Recommendation Report for Planning Permission for Works or Extension to a Dwelling

REF NO: AB/2/18/HH

LOCATION: 22 Park Place
Arundel
BN18 9BE

PROPOSAL: Replacement of 9 No. casement windows with new casements & sliding sashes & insertion of a new door opening to the east elevation (resubmission following AB/158/14/HH). This application affects the character & appearance of the Arundel Conservation Area.

WEST ELEVATION

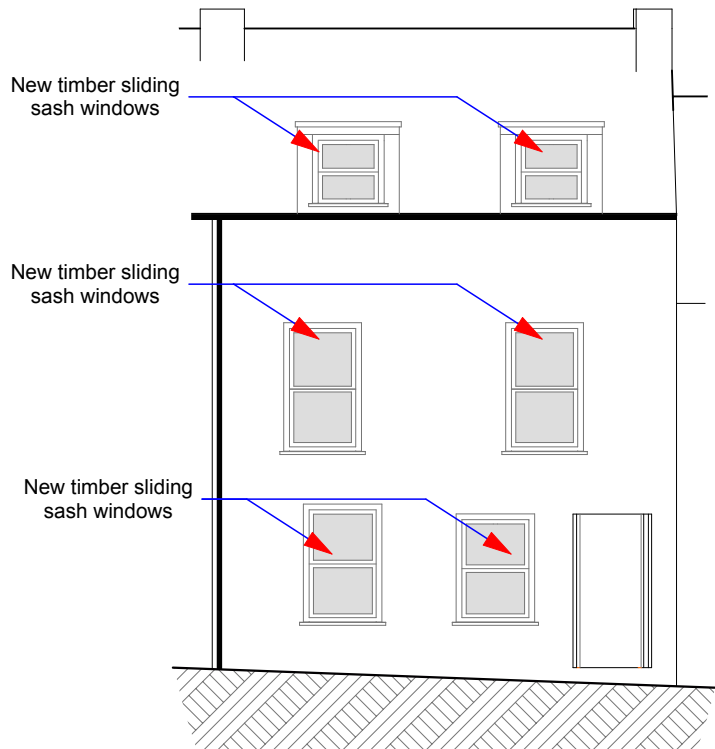
If the application is approved the style and manner of glazing should be reserved by condition. To West Elevation, the sashes should be in the same plane as existing, white painted softwood and single glazed, vertical sliding sashes. It is suggested that windows from another property in the range be copied (rails, glazing bars, horns etc), to ensure visual harmony.

- 3 No development shall commence unless and until details including cross sectional drawings, materials and colours to be used in the replacement windows and new door hereby approved

have been submitted to and approved by the Local Planning Authority and the details so approved shall be used in their construction and retained thereafter.

EAST ELEVATION

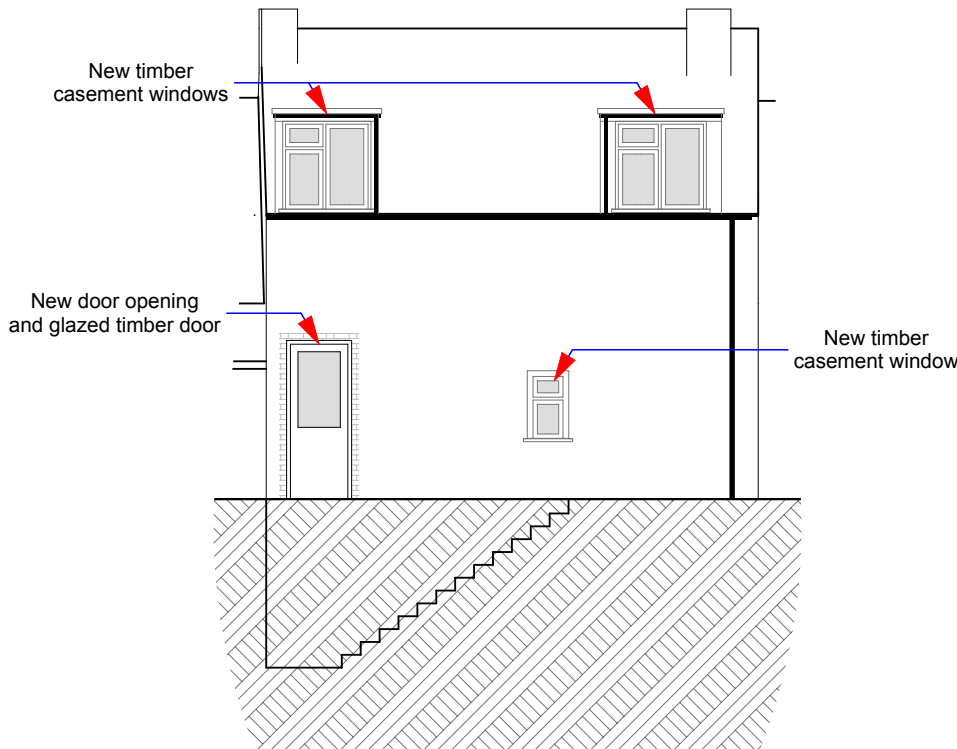
Timber casements to East Elevation should be replicated as existing in white painted hardwood, single glazed. The door style should also be reserved by condition, as there is insufficient detail at a scale of 1:100 to provide comment, although the insertion of a door at this point is supported.

The insertion of a new door will be on the rear elevation and as such will not be visible from the street. In its use of glazed timber, it is considered acceptable in design terms. The proposal is therefore considered to preserve the character and appearance of the surrounding Conservation Area.
